City of Portland, Maine - Building or Use Permit Application

Permit No: 2012-65529	Issue Date:	CBL: 013 K045001
--------------------------	-------------	---------------------

Location of Construction: 109 SHERIDAN ST	Owner Name: ROUDA NEIL W	Owner Address: 109 SHERIDAN ST	Phone:
Business Name:	Contractor Name: American Carpentry	Contractor Address: 3 Orchard Circle Westbrook	Phone (207) 797-8229
Lessee/Buyer's Name	Phone:	Permit Type: Alterations - Multi Family	Zone: R6
Past Use: Three dwelling Units	Proposed Use: Same: Three Dwelling Units	Permit Fee: \$220.00	Cost of Work: \$20,000.00
			CEO District: 1
		FIRE DEPT: <input checked="" type="checkbox"/> Approved <input type="checkbox"/> Denied <input type="checkbox"/> N/A	INSPECTION: Use Group: R-2 Type: SB MUBEC 2009

Proposed Project Description:
1st floor: build a closet, move 3 doors, change suspended ceilings to sheetrock (5/8"), and other work as shown

109 Sheridan St. 1<sup>st</sup> floor

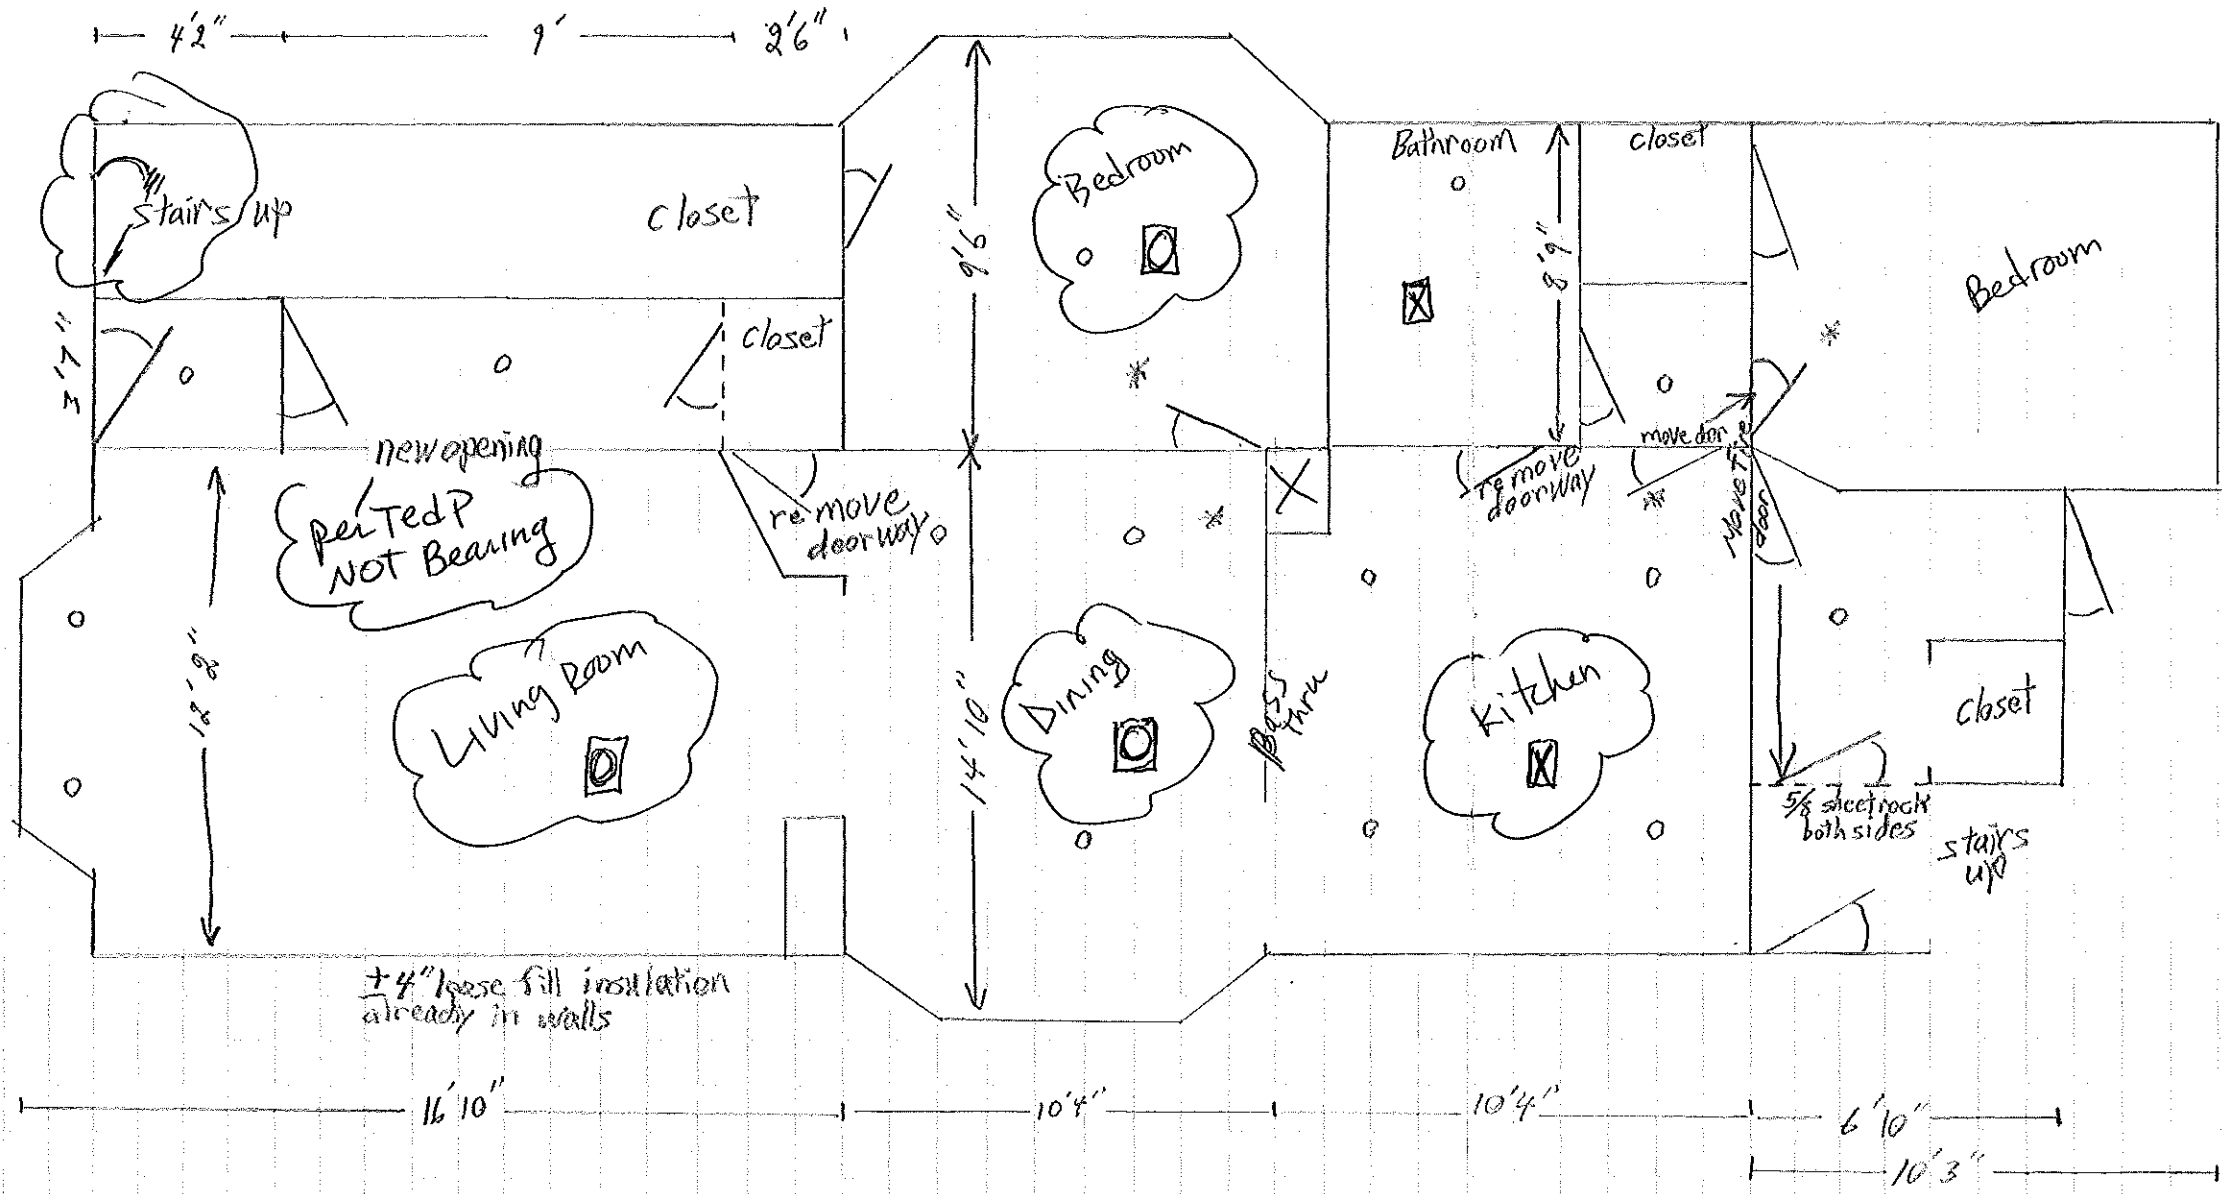
- 1) PER IBC SEC. 713.4.1.2(2), MEMBRANE PENETRATIONS OF FIRE RESISTANCE RATED ASSEMBLIES BY STEEL ELECTRICAL BOXES OR RECESSED LIGHT FIXTURES THAT DO NOT EXCEED 16 SQUARE INCHES IN AREA ARE ALLOWED ONLY IF THE AGGREGATE AREA DOES NOT EXCEED 100 SQUARE INCHES PER 100 SQUARE FEET OF CEILING AREA. BOXES OR FIXTURES THAT EXCEED 16 SQUARE INCHES SHALL BE RATED TO MAINTAIN THE FIRE RESISTANCE RATING

- 2) All penetrations between dwelling units and dwelling units and common areas shall be protected with approved firestop materials, and recessed lighting/vent fixtures shall not reduce the (1 hour) required rating per IBC Sec. 712.

- 3) Per IBC Sec. 3401.3 for existing buildings and dwelling units, compliance with smoke and carbon monoxide detection shall be per City Ordinance Chapter 10 and NFPA 101

- 1) Single- and multiple-station smoke alarms shall be provided in each sleeping room and outside of each sleeping room inside the dwelling units. They are not required in the common areas outside of the dwelling unit. New smoke alarms shall be hardwired with battery backup and photoelectric. The unit undergoing renovation shall have the smoke alarm interconnected so that if one alarms they all alarm.

- 2) Doors between the exit stairs and dwelling units, storage ares, and basement shall be existing approved 45-minute fire door assemblies or 1-hour fire door assemblies if not existing approved.

- 3) Through-penetrations and membrane penetrations in fire walls, fire barrier walls, and fire resistance rated horizontal assemblies shall be protected by firestop systems or devices in conformance with NFPA 101:8.3.5 (ASTM E 814 or ANSI/UL 1479). Providing firestop labels at each firestop system or device and an onsite manual containing the detail for each firestop system or device used for the project will streamline final inspection approvals.

- 4) Carbon Monoxide is detection required in accordance with NFPA 720, Standard for Installation of Carbon Monoxide (CO) Detection and Warning Equipment, 2009 edition.
